From: [Carol Branigan](#)
To: [Cynthia Palmer](#)
Subject: RE: 6/2019/0882/OUTLINE Colesdale Farm Northaw Road West Northaw Potters Bar EN6 4QZ Outline permission for residential development of site of up to 38 dwellings following demolition of the existing buildings and structures with all matters reserved apart
Date: 22 May 2019 14:44:13

Carol Branigan
NORTHAW & CUFFLEY PARISH COUNCIL
7 MAYNARD PLACE
CUFFLEY
HERTS
EN6 4JA

DRAWING TITLE: ACCESS DESIGN AND VISIBILITY SPY DRAWING

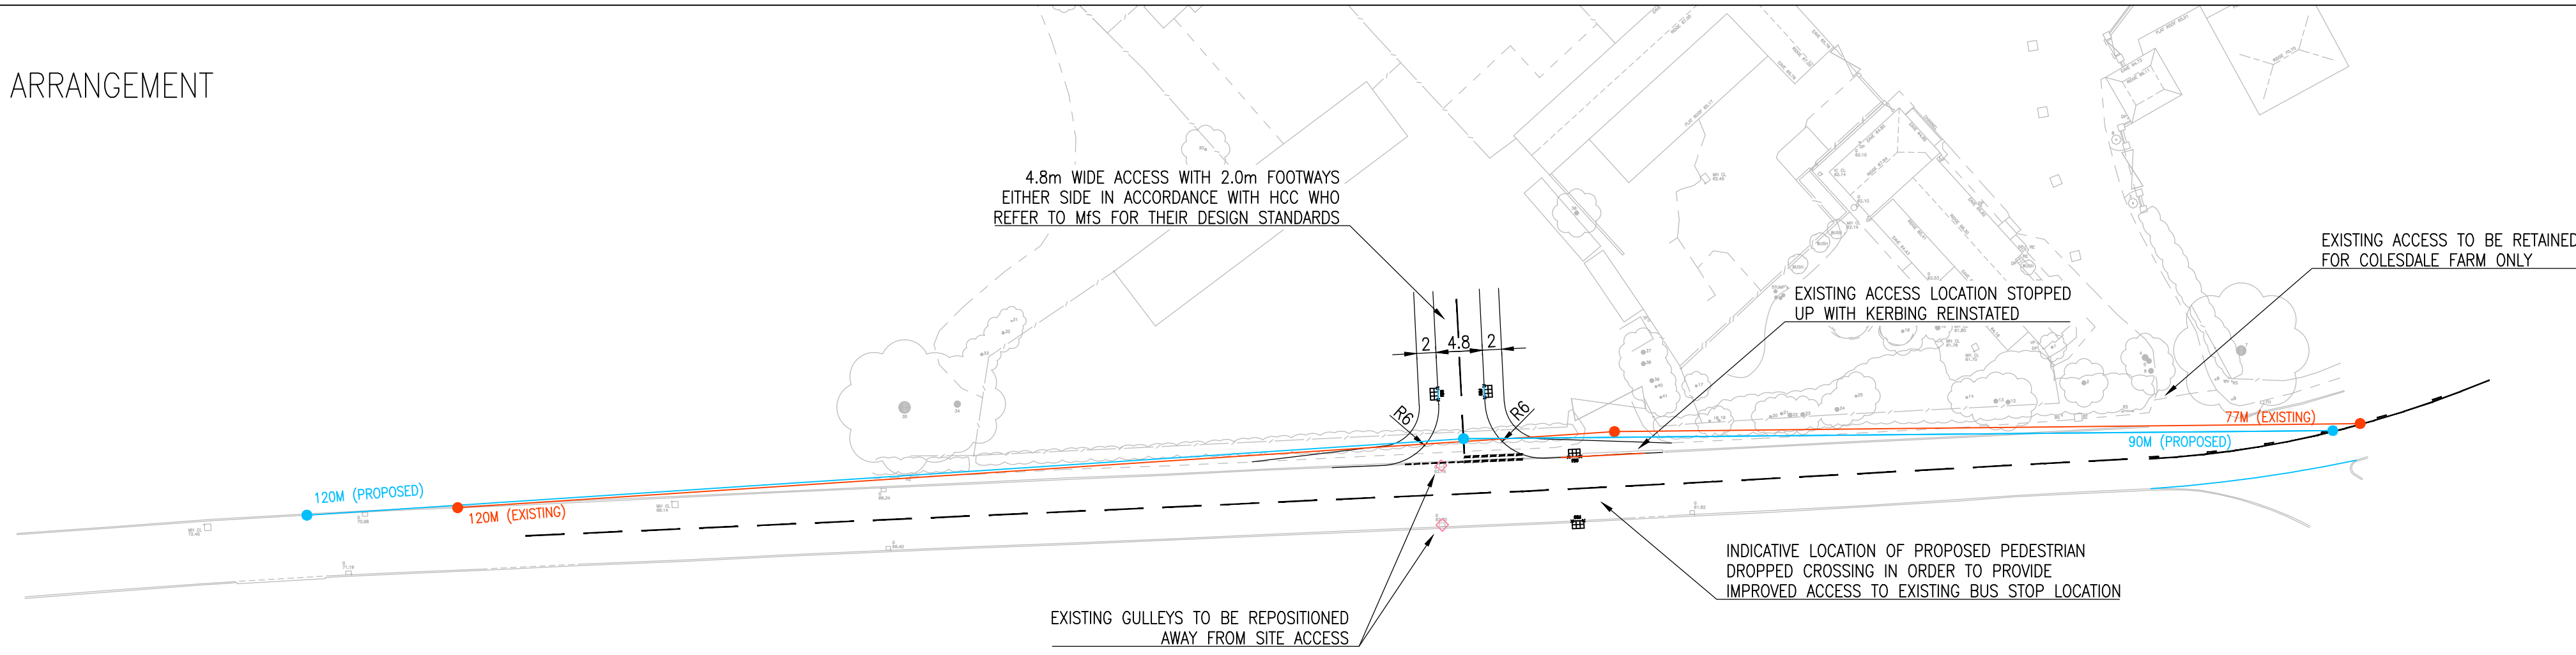
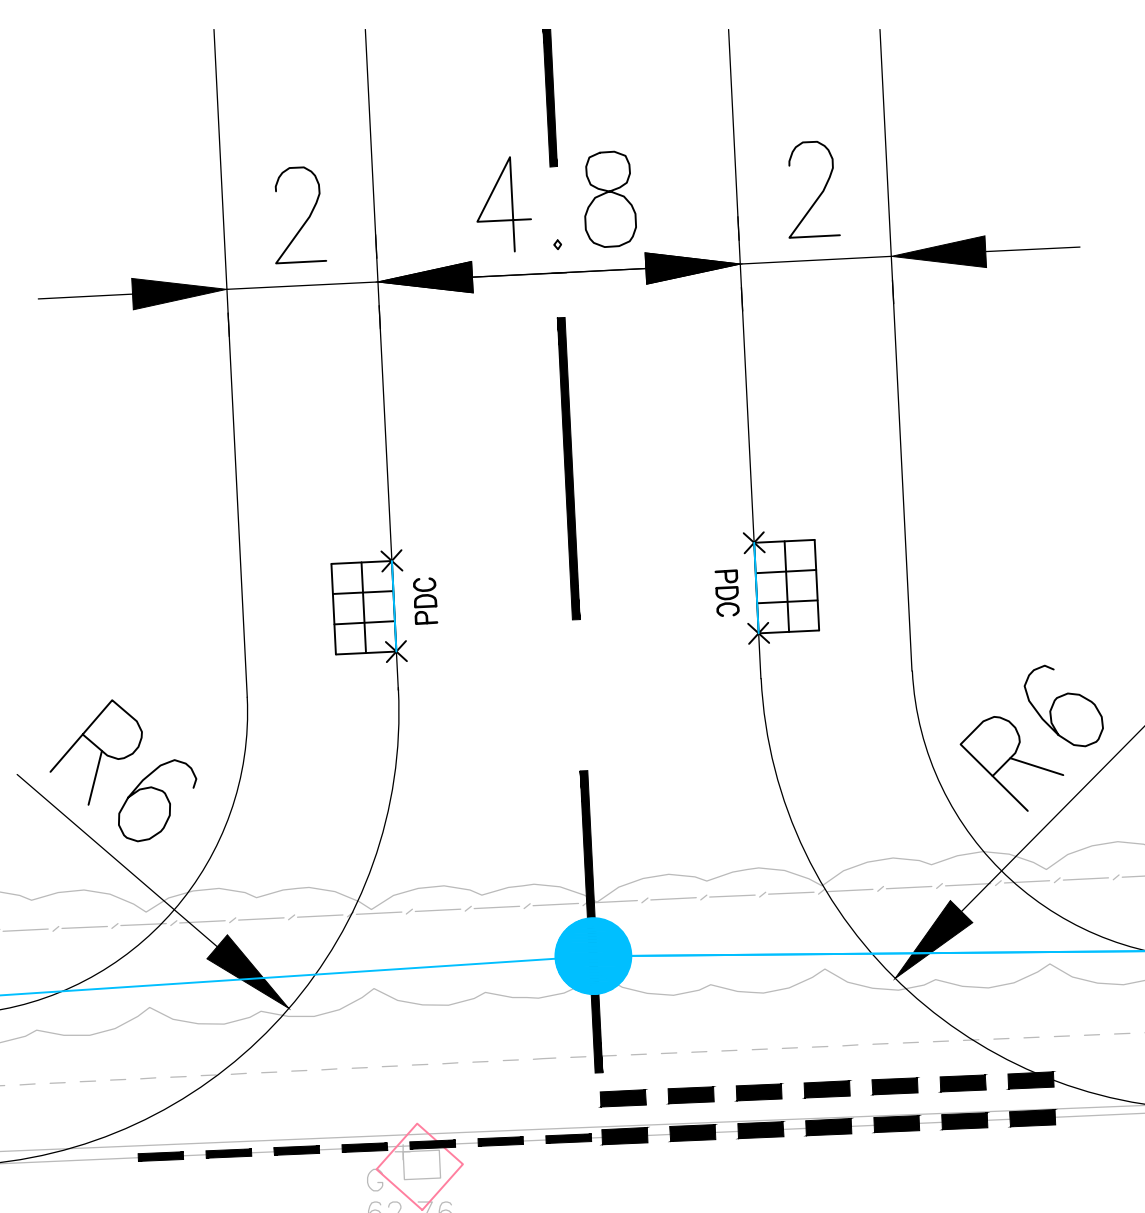
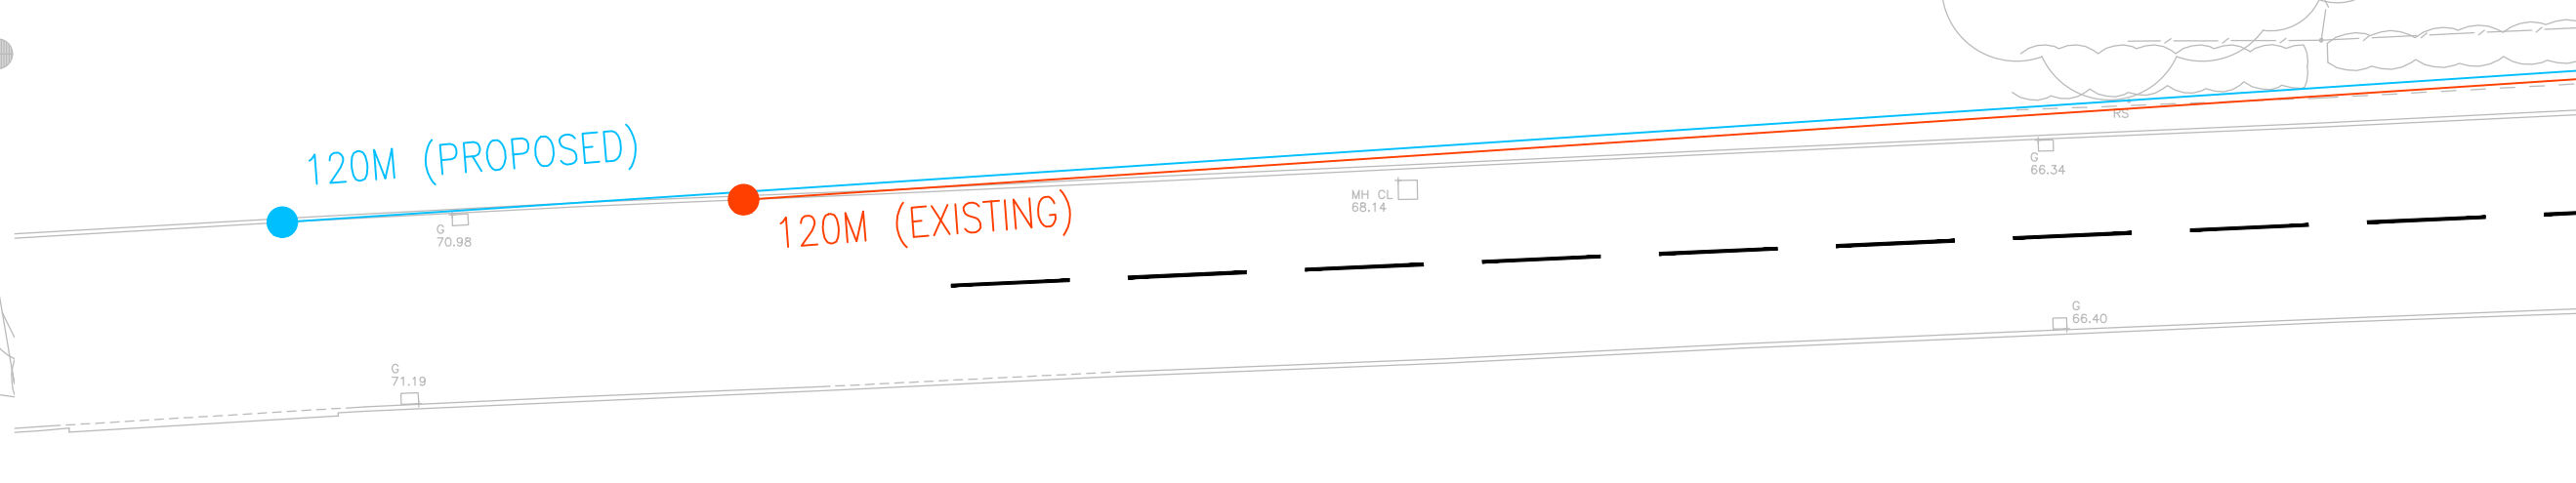
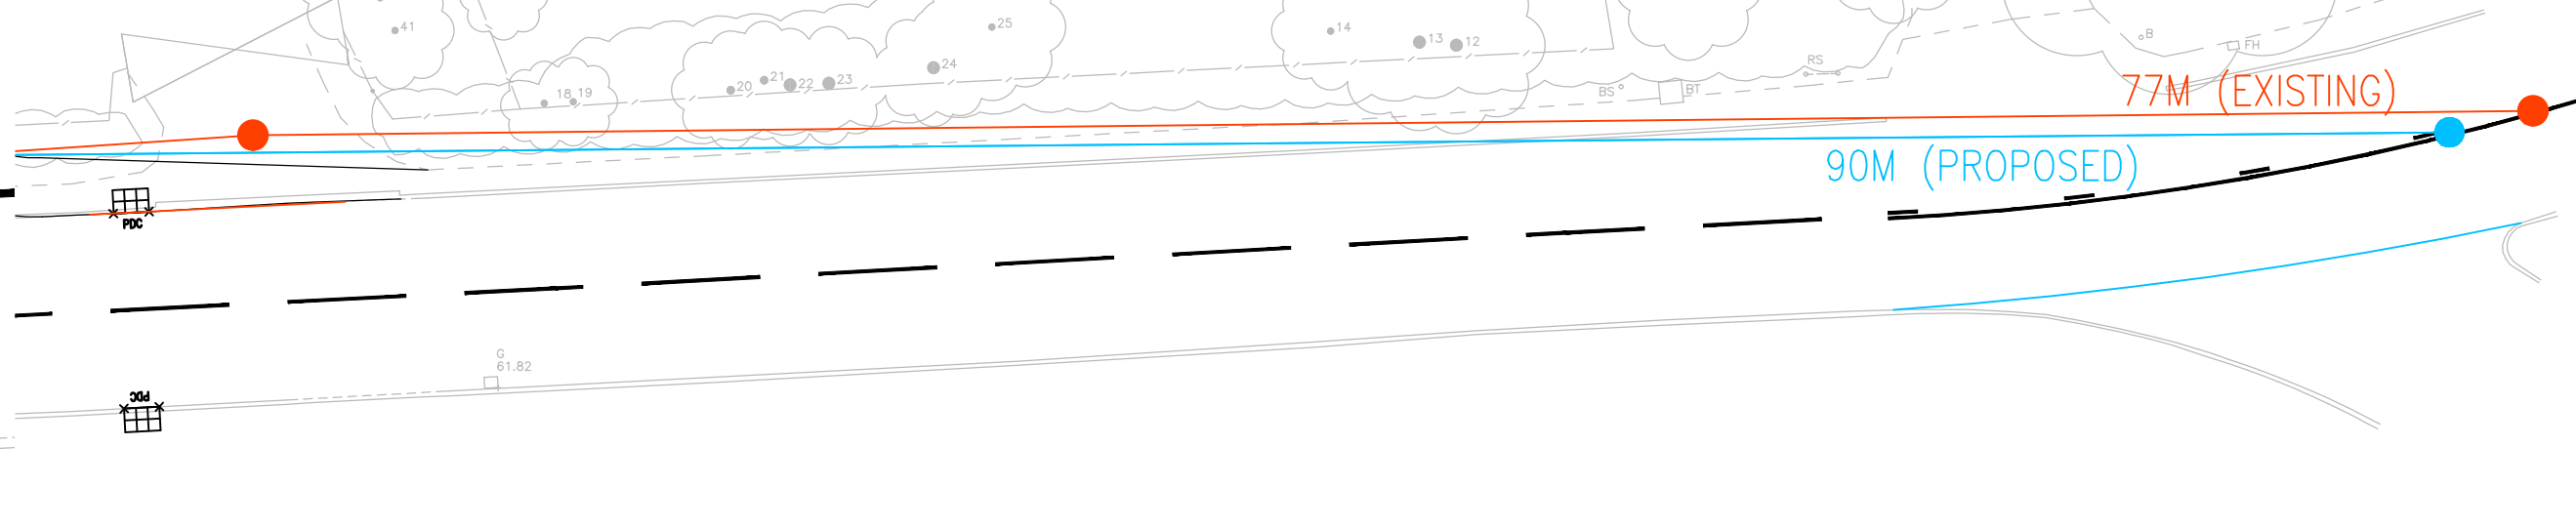
The accident figures are questionable and presumably only refer to 'reported' accidents. There are many more unreported accidents particularly at the Cattlegate Road junction. The current exit from the site is on the junction and is dangerous due to poor sight lines (it is on a bend) and fast traffic approaching the junction from the direction of Northaw

where there is a 40mph limit. The proposed new access is halfway up the hill towards Northaw where there is a blind summit. For these reasons we conclude that the potential for road accidents would be increased by this development.
